Application No: FG/62/26/HH
Site Address: 1 Greenways Crescent Ferring BN12 5EF
Description of works: Proposed detached garden room.

Thank you for your internet representation made on 27th August 2026 which has been recorded as an objection with the comments as follows:

PROPOSED ARTIST IMPRESSION OF LANDSCAPE DESIGN
(drawing provided by the client)

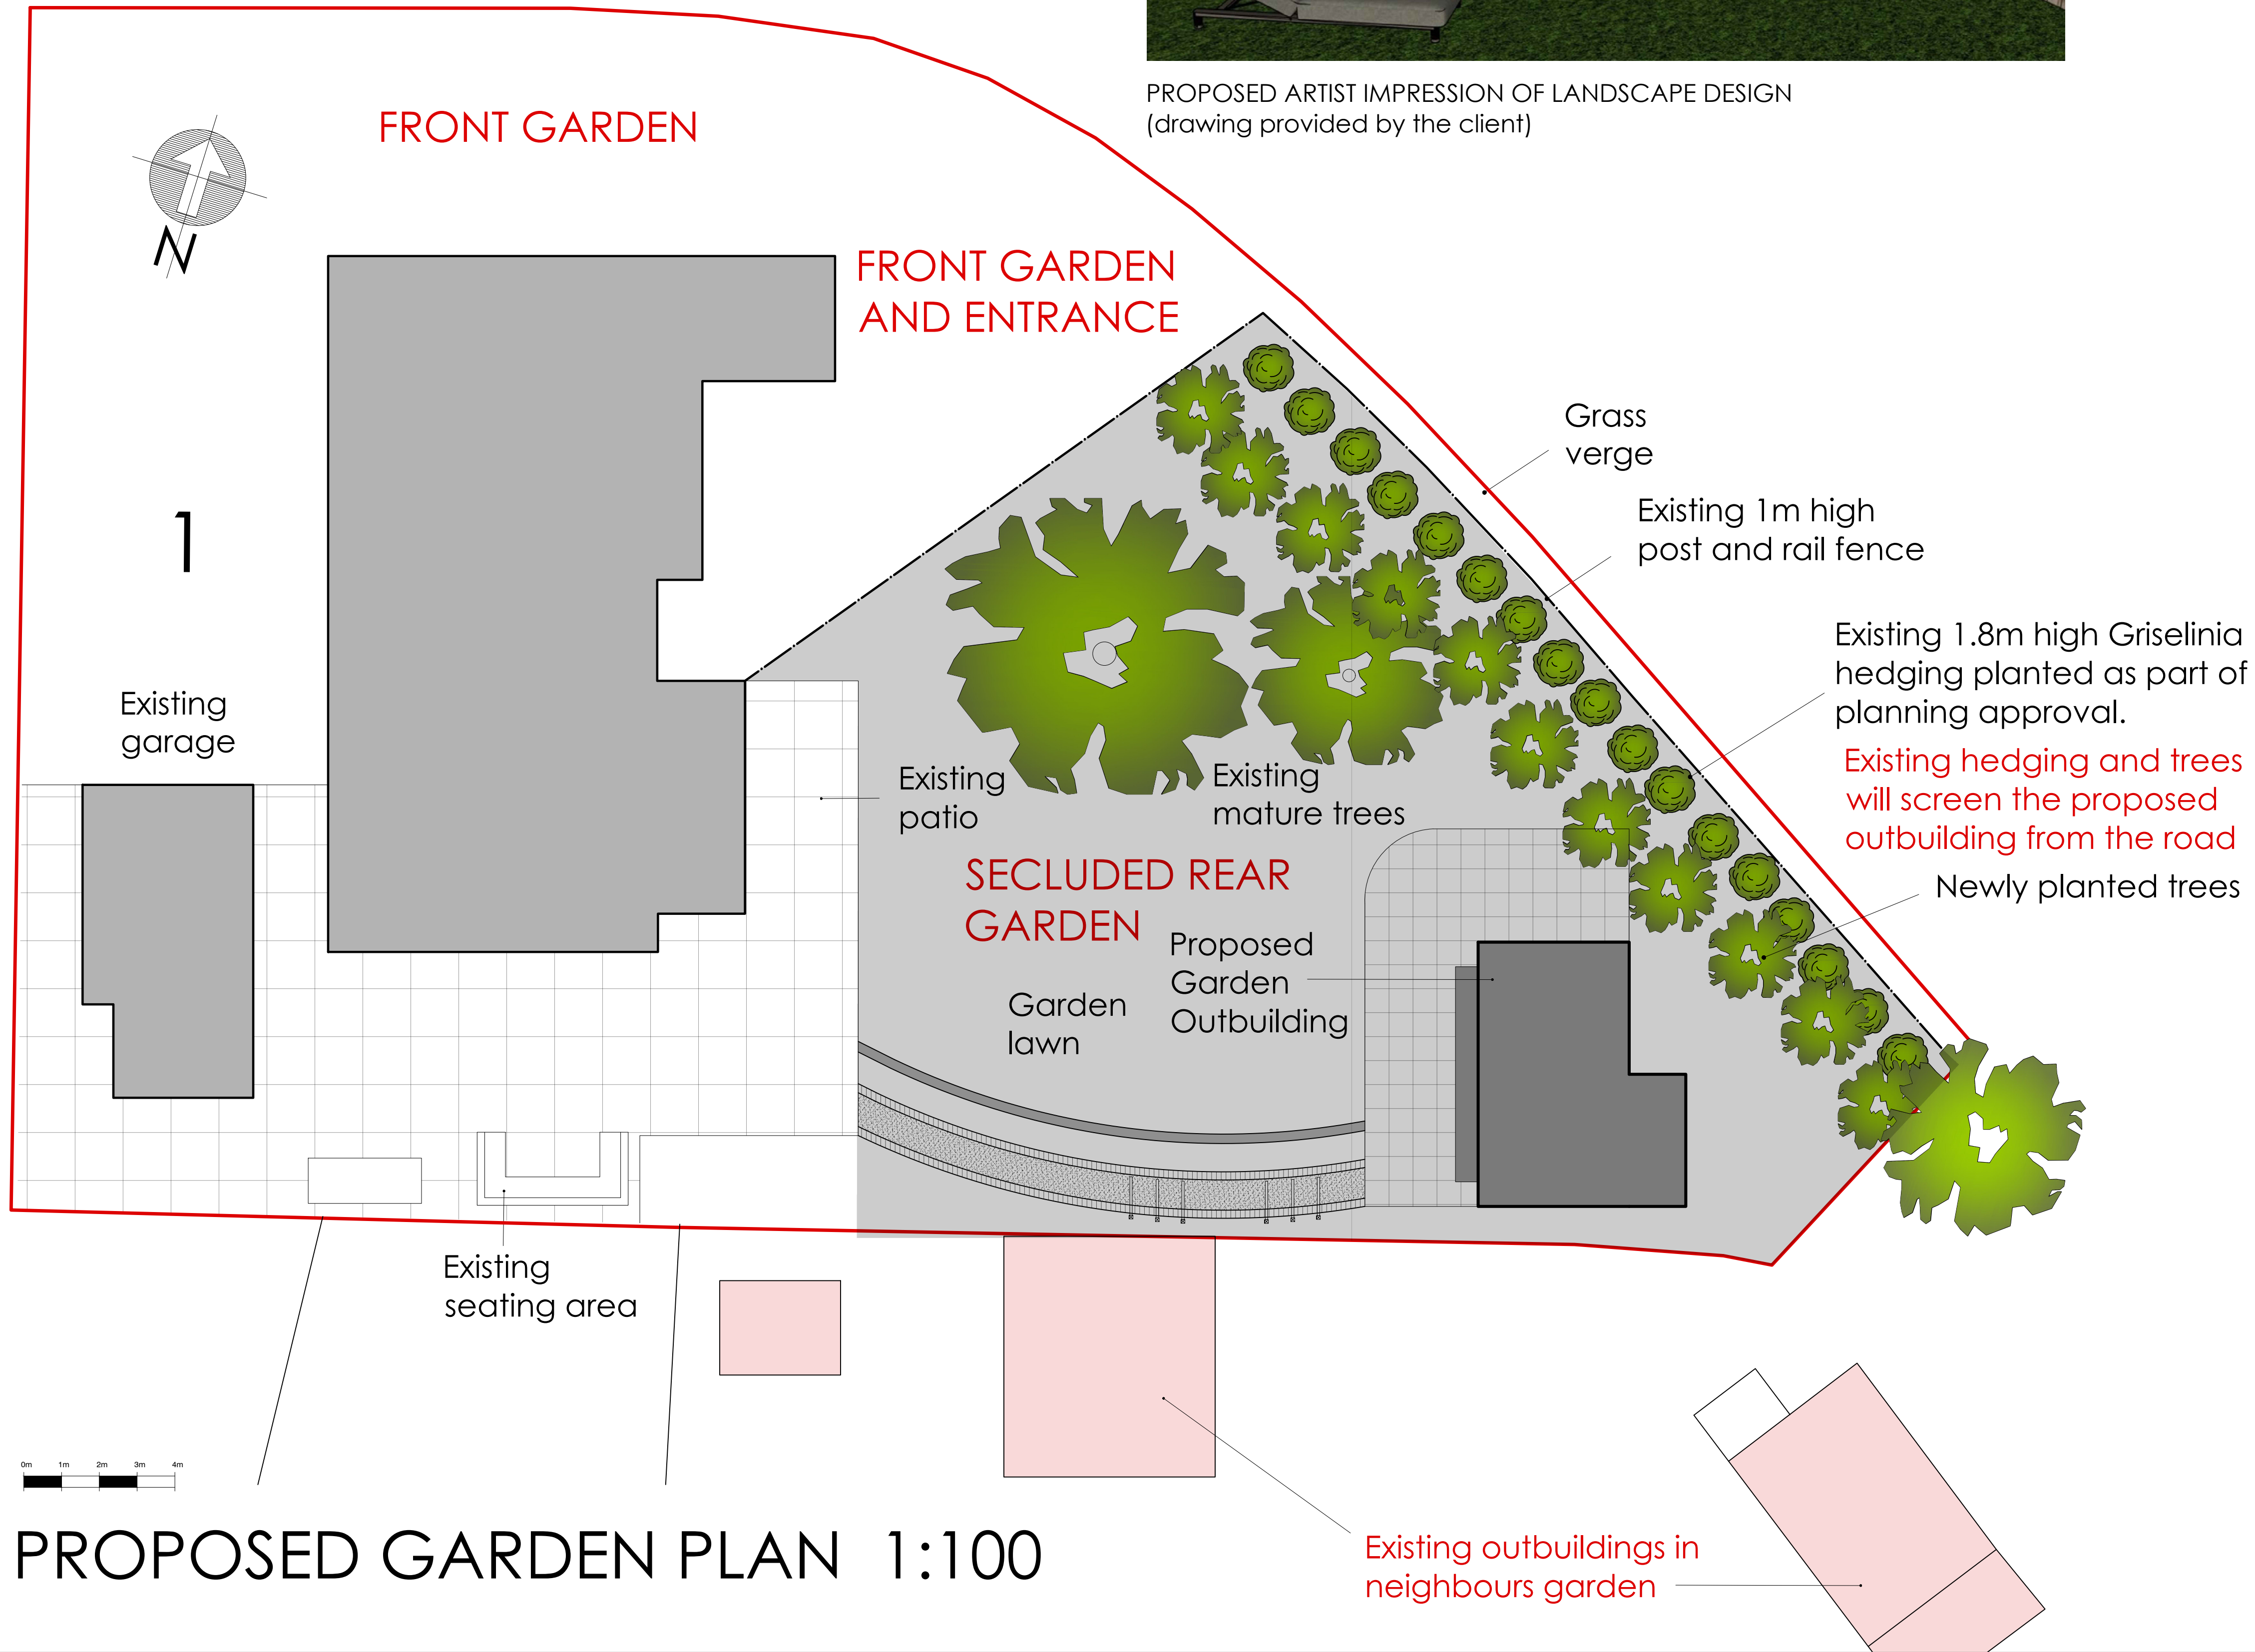
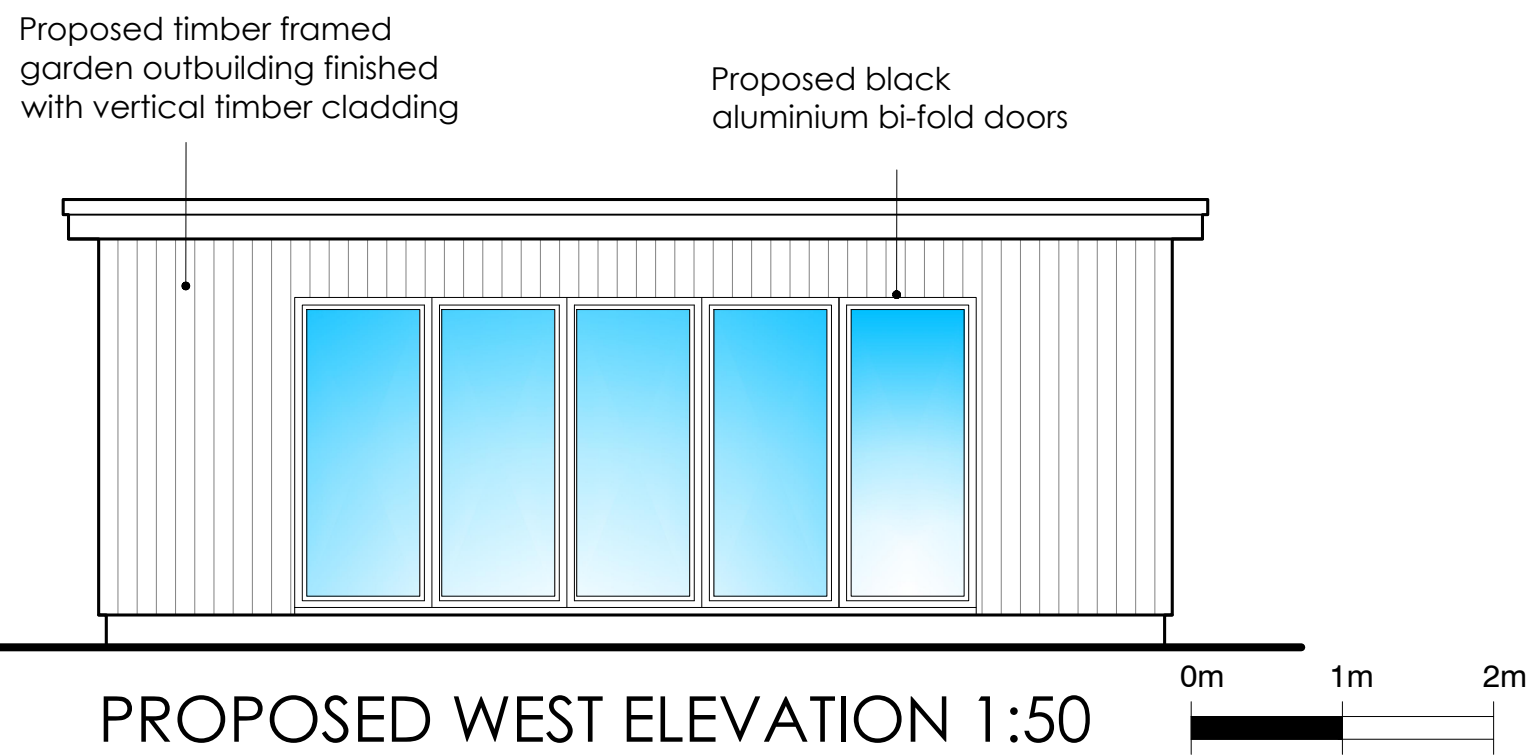
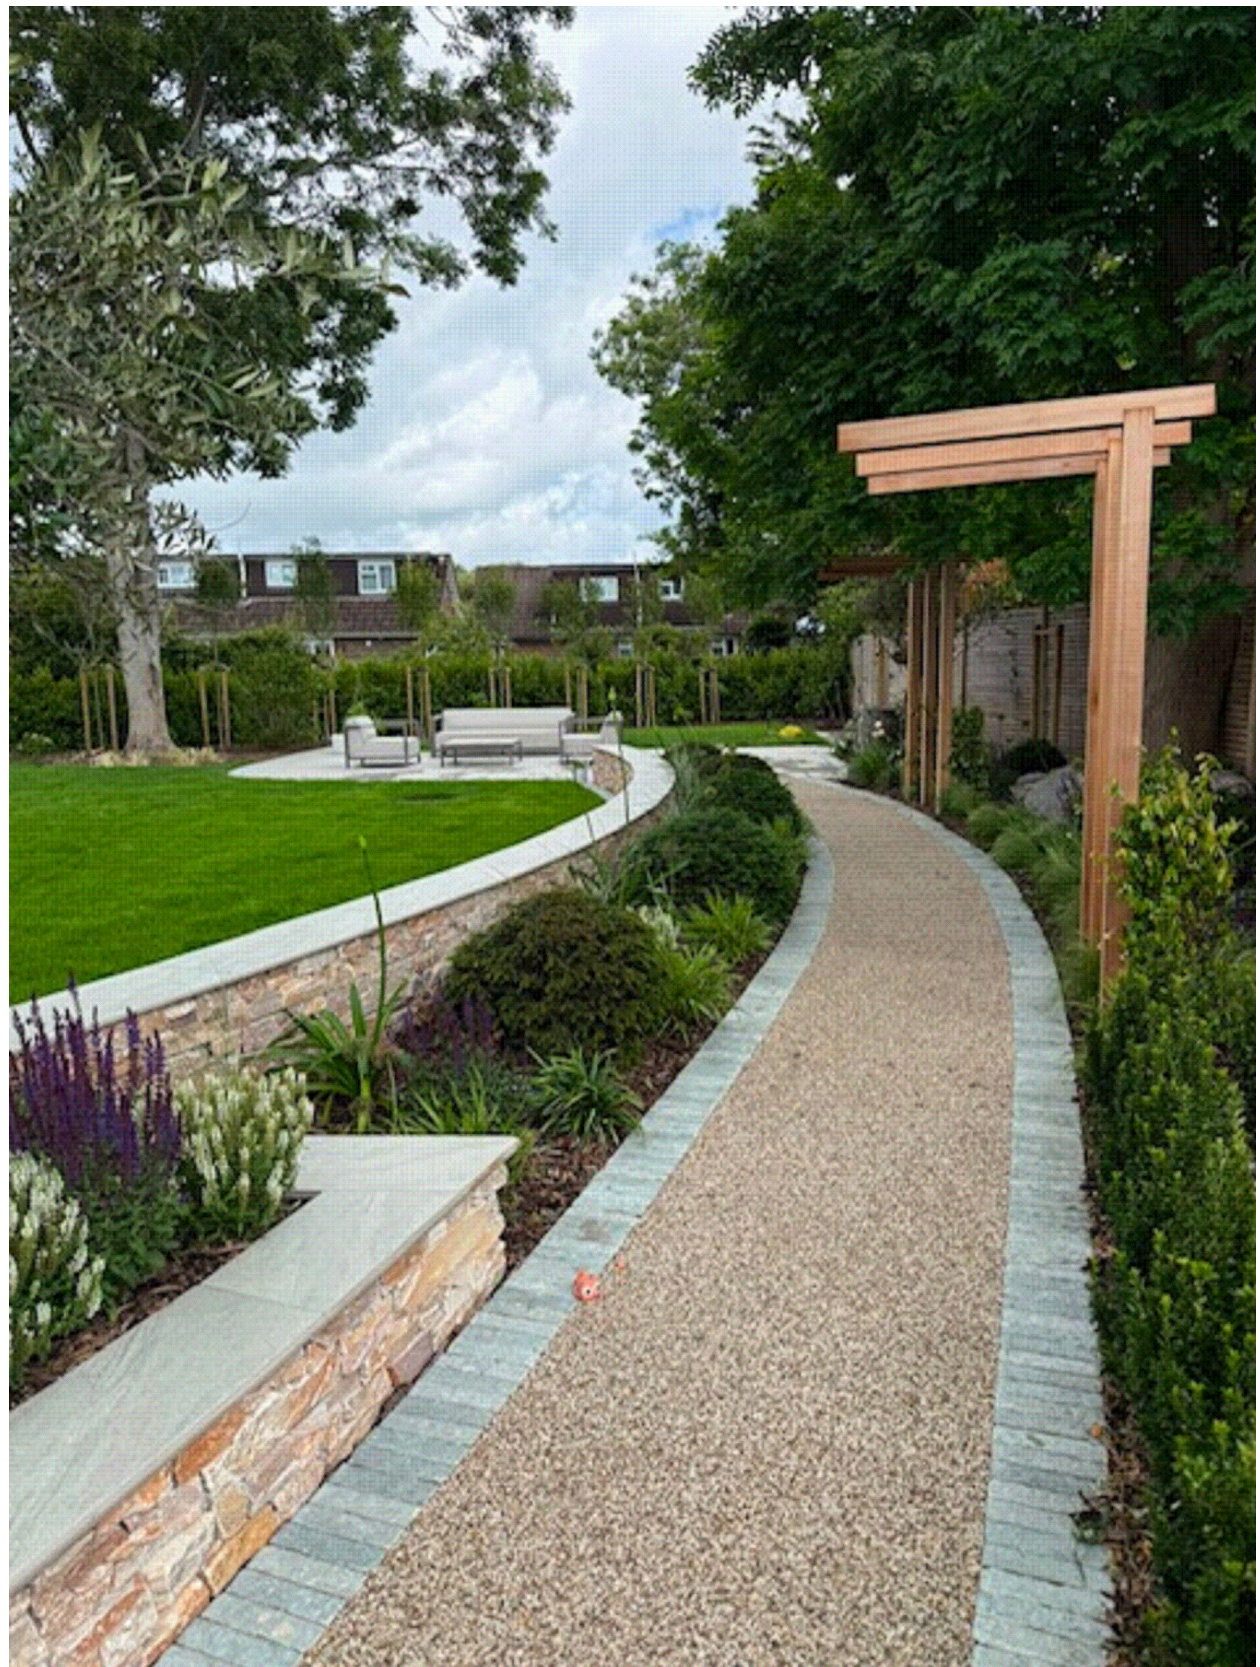
The proposals rely heavily on existing, recently planted vegetation that has not reached its shown sizes to mitigate the visual impact of the development. However, the proposal does not explicitly state that these trees and hedges will be legally retained; they are merely labelled as "existing."

- Inaccurate Screening Representation: A visual inspection from the road confirms that the current planting is less developed than the application drawings suggest. The plants closest to the proposed building are growing slowly under the canopy of larger trees. Consequently, the 3+ metre eaves and large mass of the building will be immediately visible from the road and surrounding properties until they reach the height and breadth shown on the drawings.
